Appeal Decision

Appeal Ref: APP/Z4718/D/25/3364432

42 Storthes Hall Lane, Kirkburton, Huddersfield HD8 0PT

- The appeal is made under section 78 of the Town and Country Planning Act 1990 (as amended) against a refusal to grant planning permission.
 - The appeal is made by Mr David Knight against the decision of Kirklees Metropolitan Council.
 - The application Ref is 2024/62/92807/E.
 - The development proposed is the installation of an air source heat pump.
-

Side elevation - current

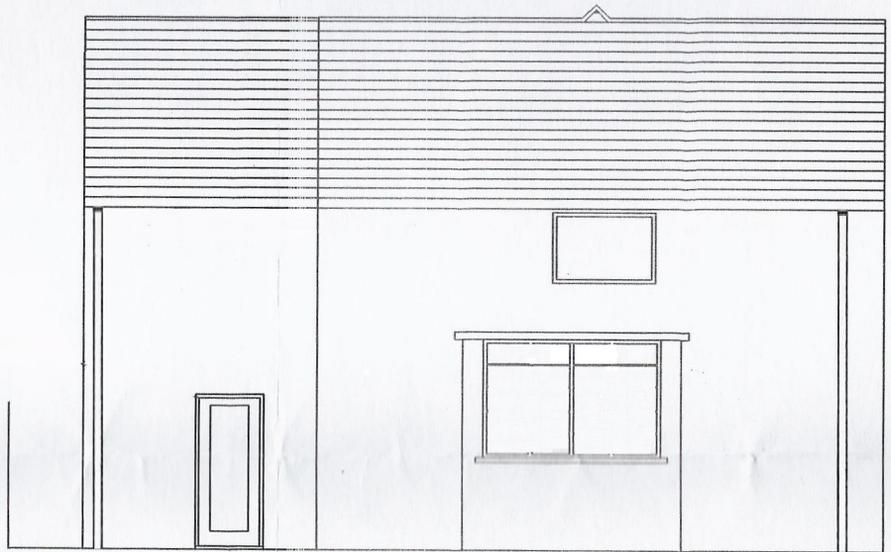
5. The appeal property, No 42 Storthes Hall Road, (No 42) is located within a road of semi-detached properties with uniform front building lines and which are separated from their non-attached neighbouring property by a shared driveway.
6. The Microgeneration Certification Scheme (MCS) -Planning Standards indicates that in order to be permitted development an Air Source Heat Pump (ASHP) must be certified to have a sound level that does not exceed 42dB. The proposal exceeds the limits set out in the General Permitted Development Order hence the need to submit the specific planning application.
7. The proposed ASHP would be installed behind a porch sited on the side elevation of No 42. Whilst it would face the garage associated with the appeal property away

- from the side elevation of No 43, the adjacent wall and window within the recessed area in which it would be sited could reflect noise towards No 43. It therefore has the potential to unacceptably harm the living conditions of the occupiers of No 43.

8. The Council's Environmental Health Team have advised that in the light of the noise levels indicated in the MCS assessment, a noise assessment undertaken by an acoustic consultant should be submitted to determine the suitability of the ASHP in this location. Whilst I appreciate the frustration of the appellant at the initial response from the Environmental Health Team, I do not read their subsequent comments as objecting in principle to the installation of the heat pump. Rather that a full assessment of the proposal and the specific circumstances of the model to be used, its noise levels and the physical environment and context in which it would be placed is required.
